1 Christ - Re: 50 Industrial Wy., BP#2014-01701 plan review comments

GRANT HAYS ASSOCIATES
FIRST FLOOR
FACILITY CODE
COMPLIANCE PLAN
DRAWING TITLE
SCALE 1/16" = 1'-0"
DATE 7/25/2014
DRAWN BY SAM/MPH
JOB NO. 140560
DRAWING NO.
AC-1

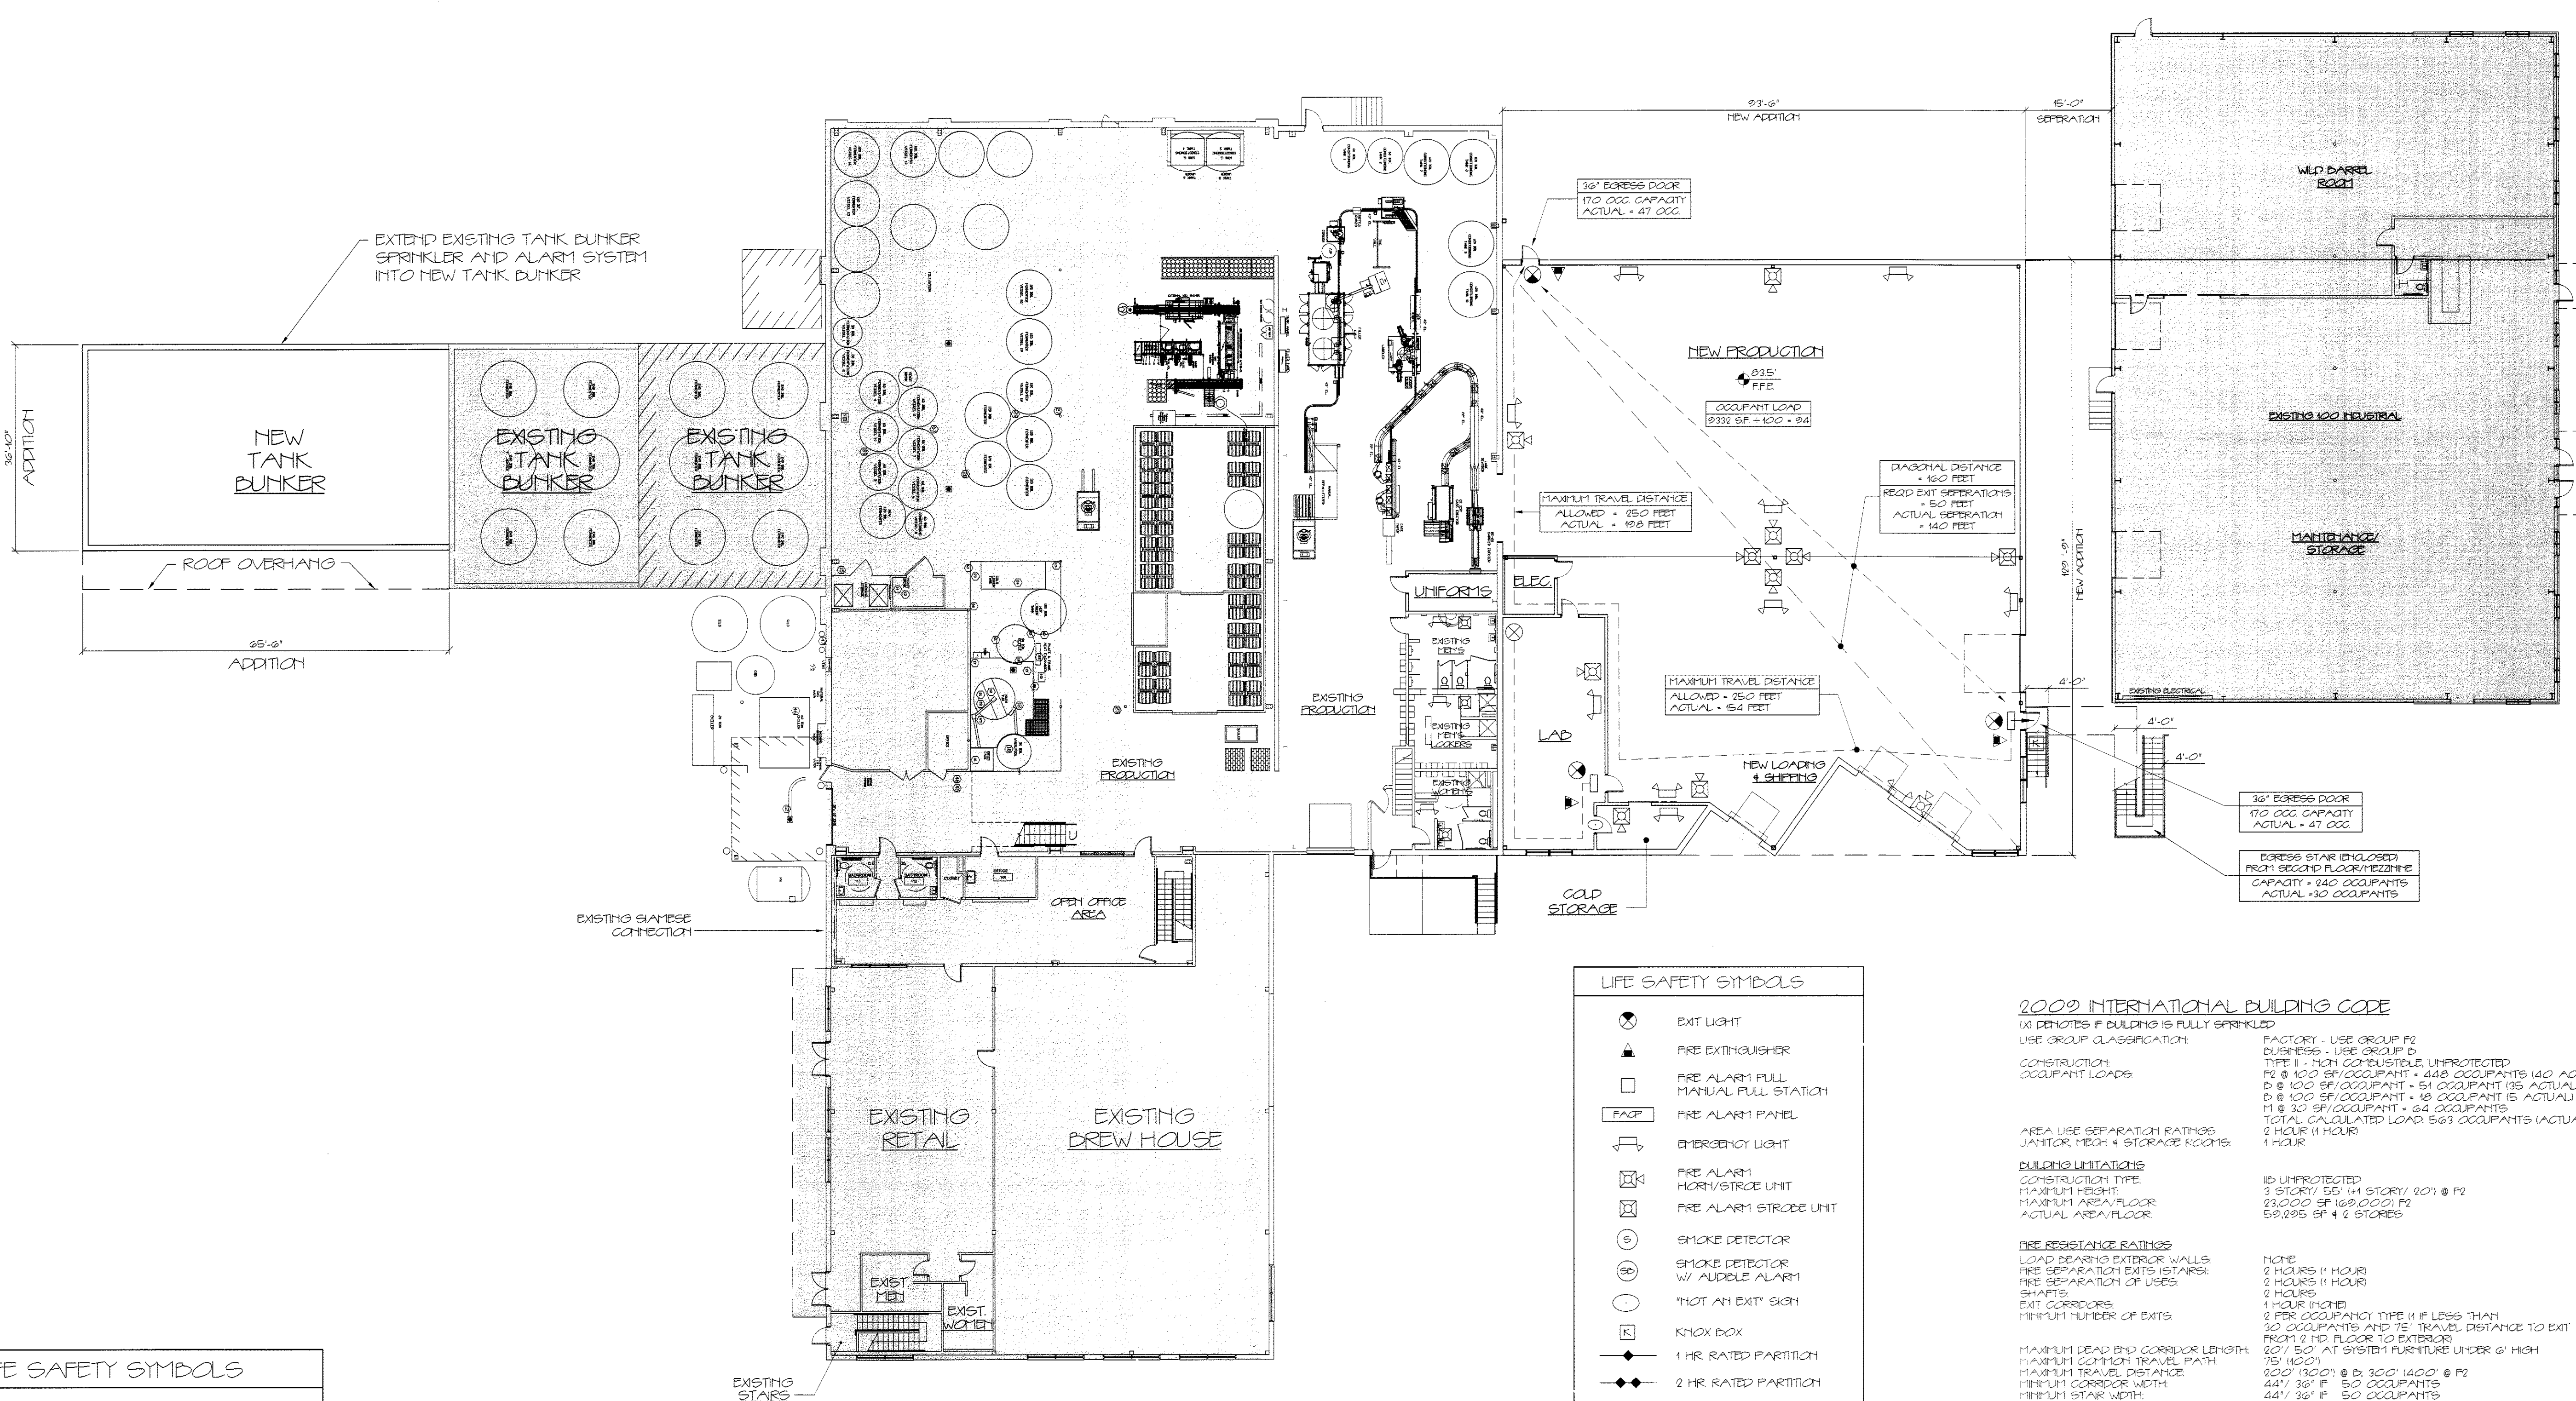
I had a chance to start the review today, and can't seem to find the code analysis and a life safety plan. Hopefully Mike Hays can clarify this. Also, the application did not detail specifically this project, ie. location, size, phase (?). The set of drawings included AC-1 and AC-2, which are the Architectural Code sheets for the first and second floor levels depicting the entire Plant. They also identify the new additions for this phase with the relevant code criteria. There are full 2012 NFPA 101 and 2009 IBC code summaries on these sheets also. I've attached a set for your convenience in case the original submission did not include them.

See the answers to the code questions below in RED. I will let Paul/Rick Meek answer the scoping/phasing questions.
